October 5, 2022

Molly McGuire
Assistant Planner
Community Planning & Development
City of Mercer Island
9611 SE 36th Street
Mercer Island, WA 98040
Molly.McGuire@mercerisland.gov

**RE: Comment Letter for Proposed Demolition and Rebuild of 6950 SE Maker Street
Permit No. 2207-019**

SHORING PLAN
SCALE: 1/4" = 1'-0"

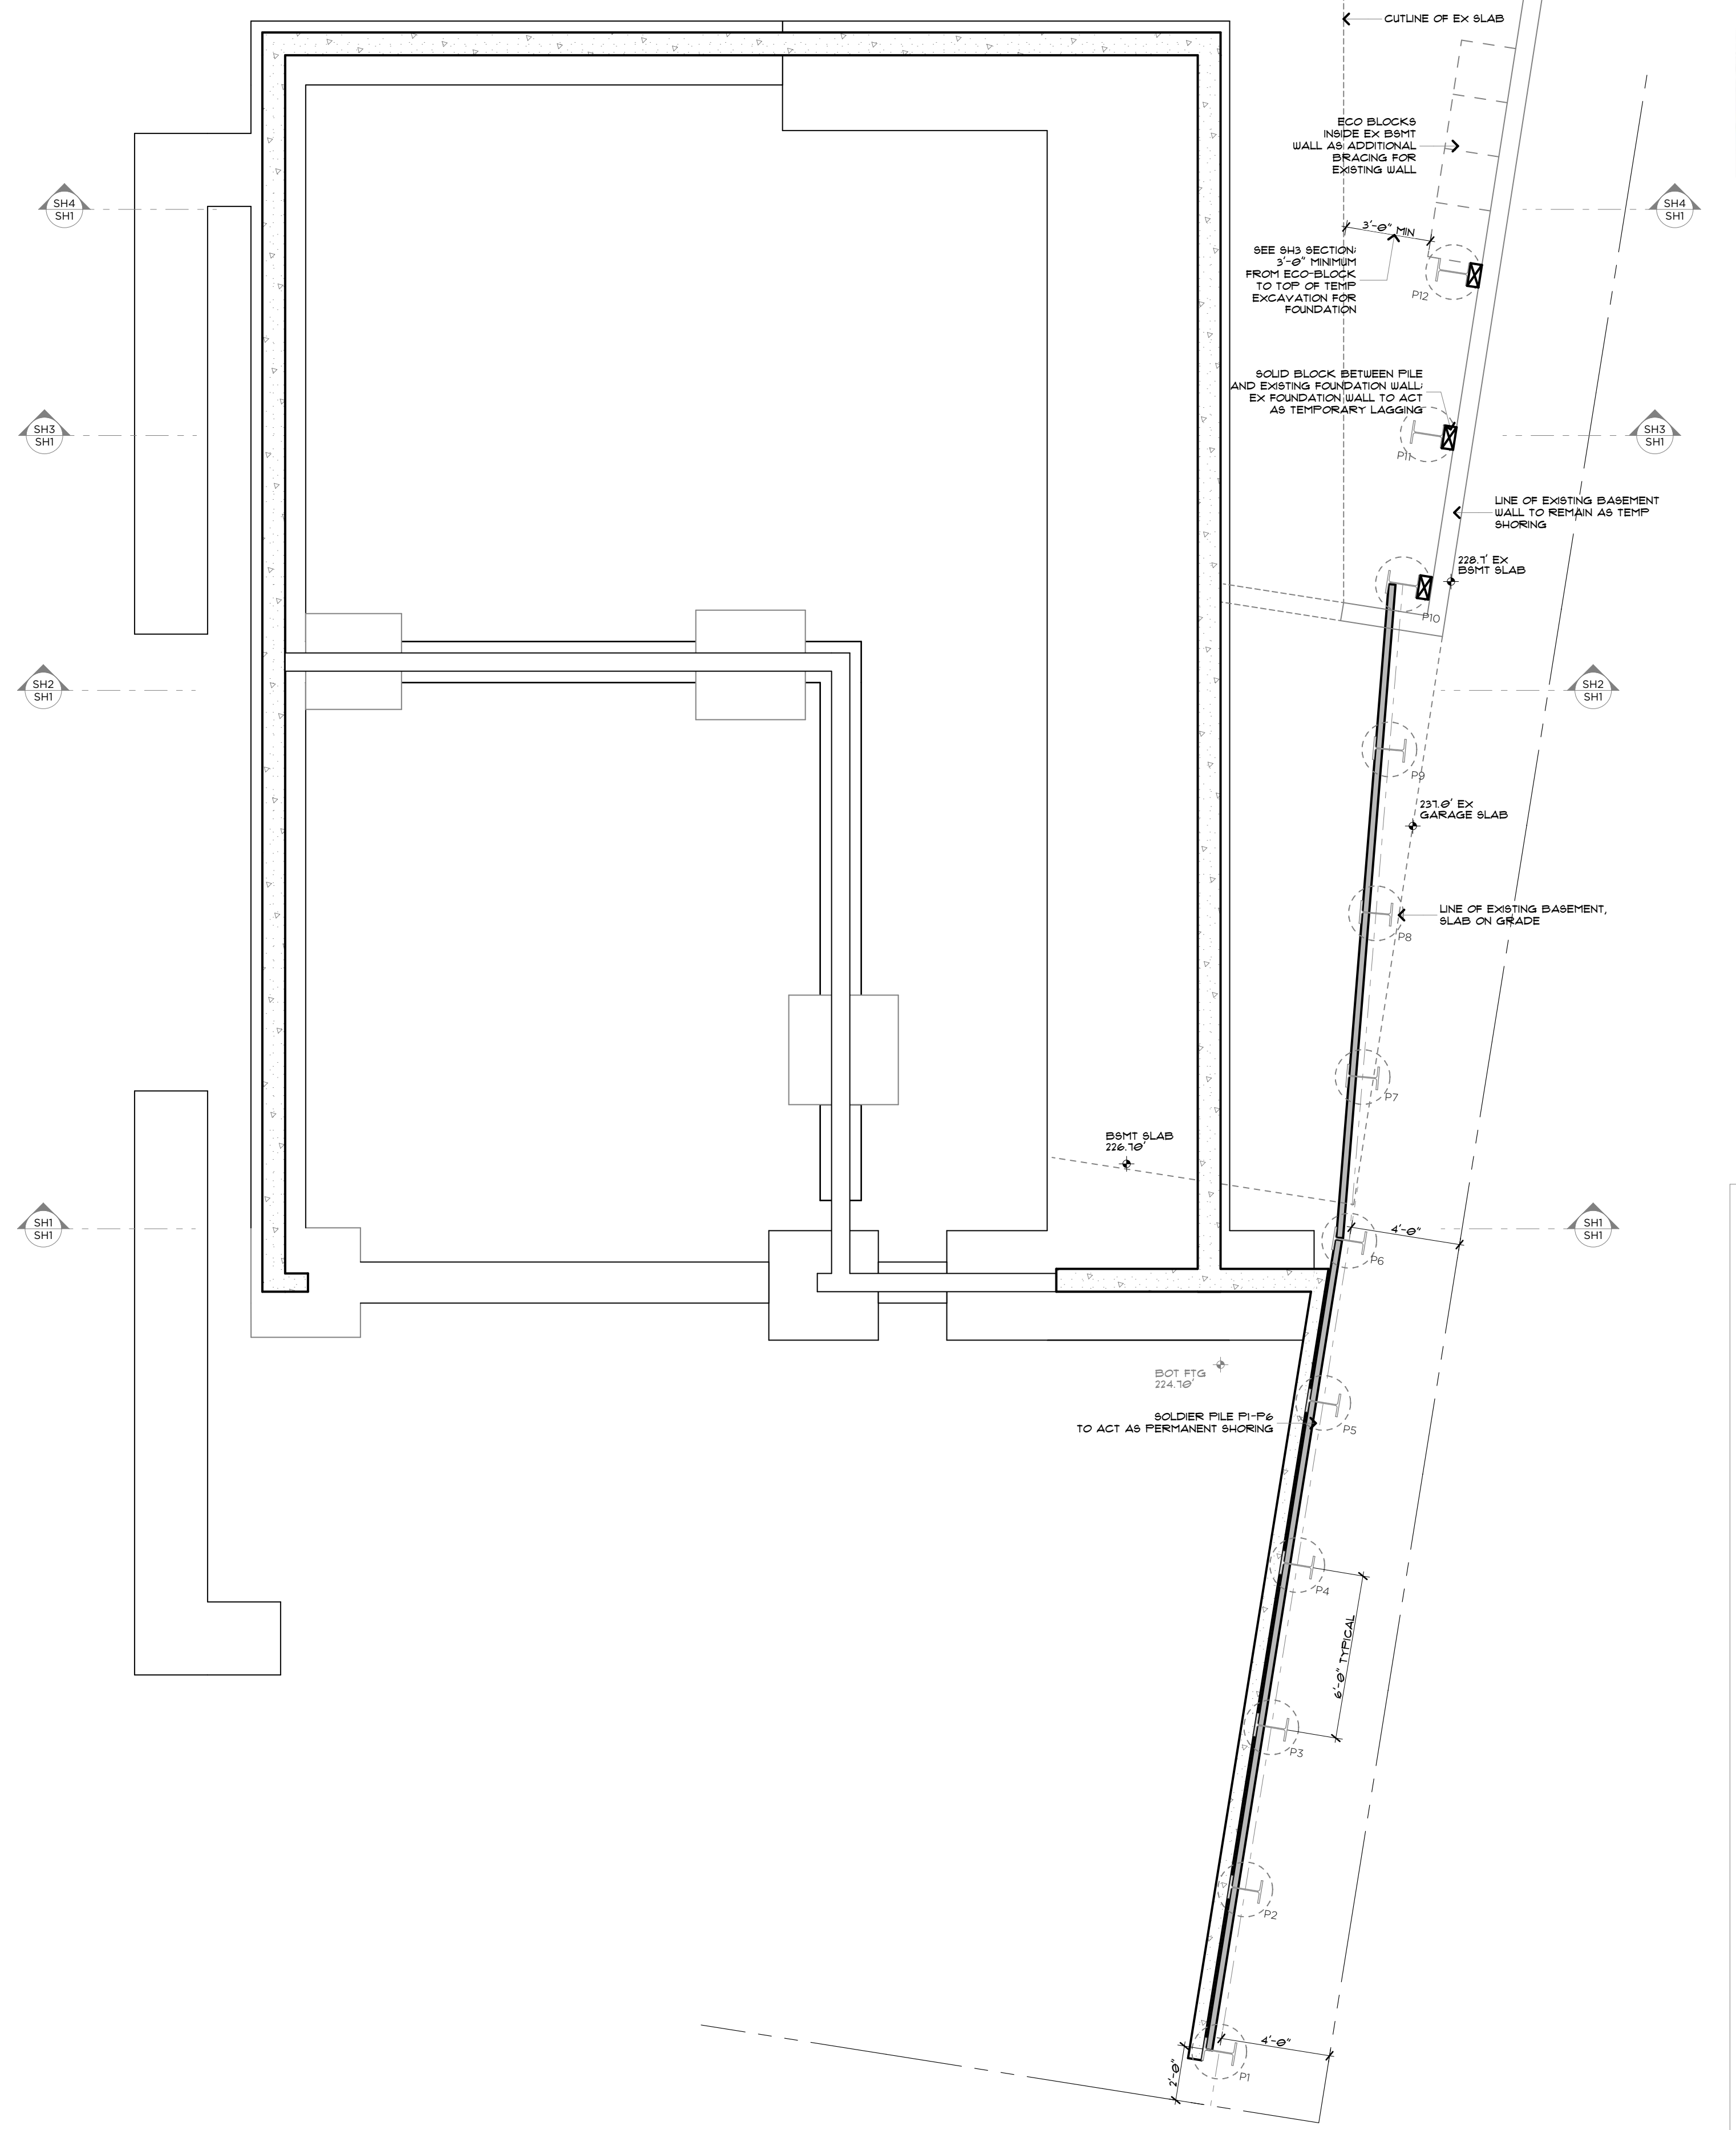
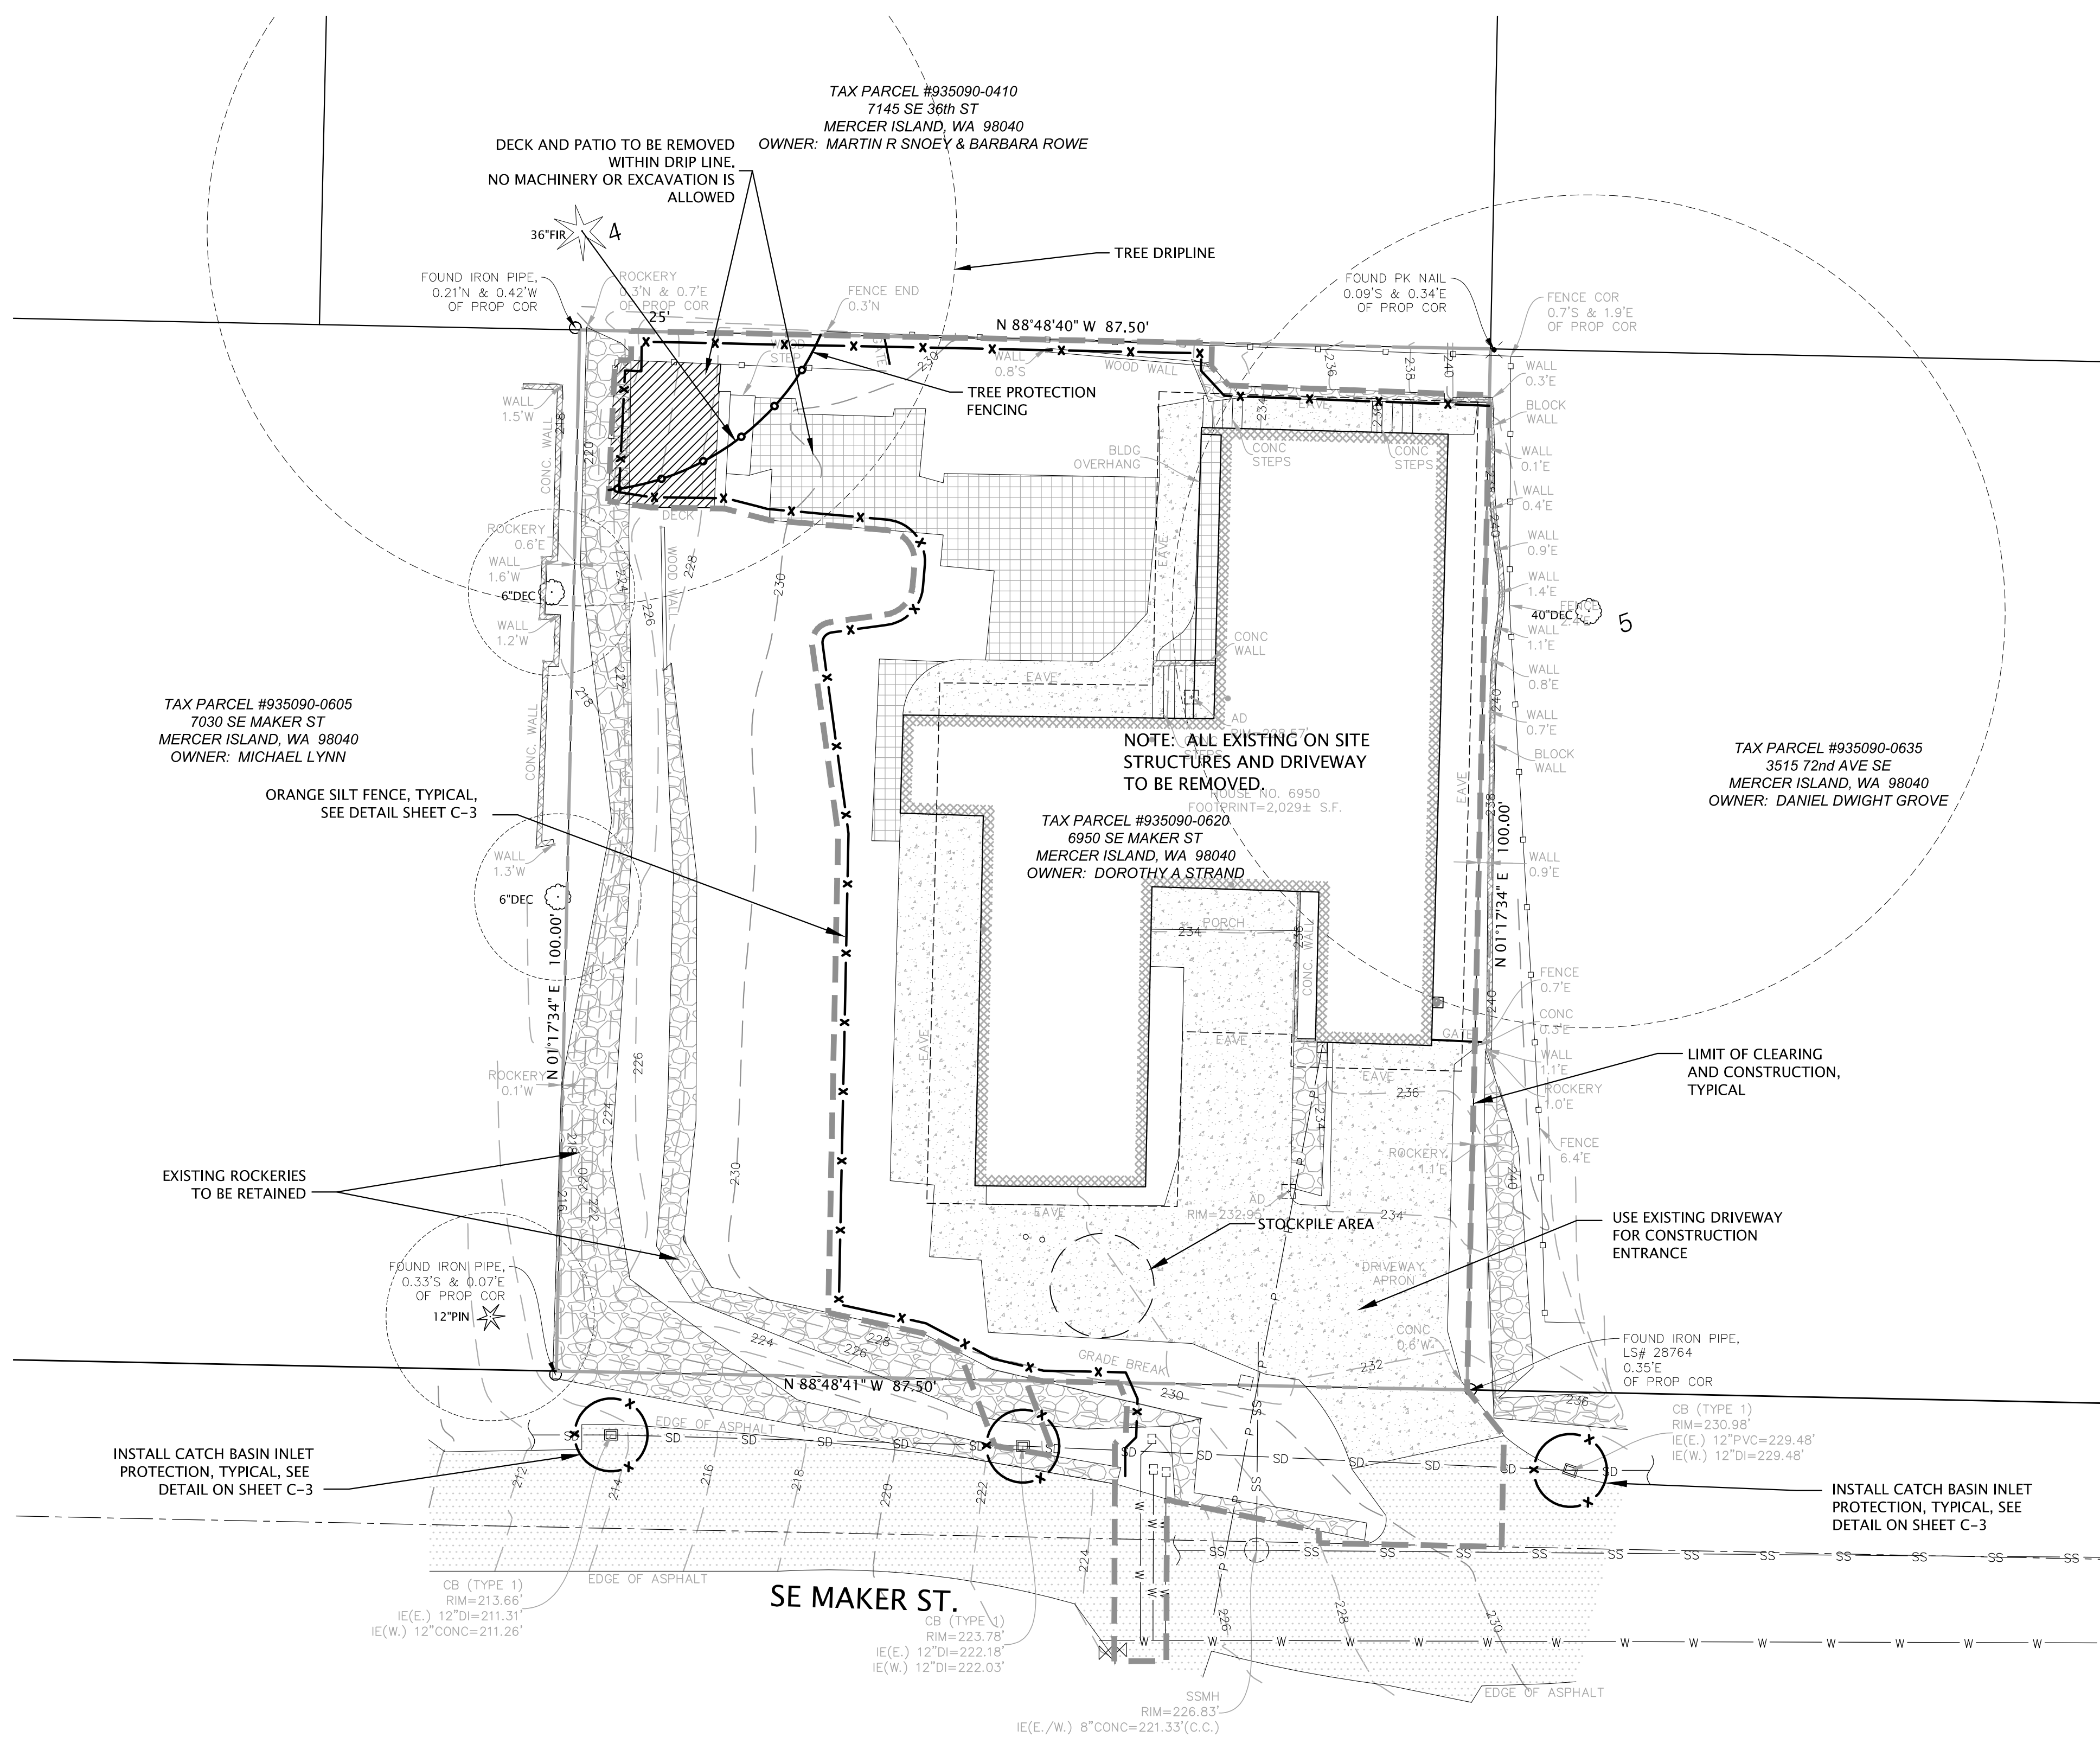
- An extensive slope stabilization system is necessary to prevent future movement of the fill and western rockeries;
- No sprinkler system should be installed in the western yard due to potential for leakage and failure.

The Geotech Study states that “detailed plans were not available at the time” of the Geotech Study.⁶ And, to date it is unclear from the permit plans whether additional analysis of the detailed project plans took place. For instance, parts of the proposed structure are closer than the 25 foot (and even the 20 foot) recommended buffers, and construction and staging will likely occur within the west side of the project. It is also unclear whether an adequate slope stabilization system will be implemented.
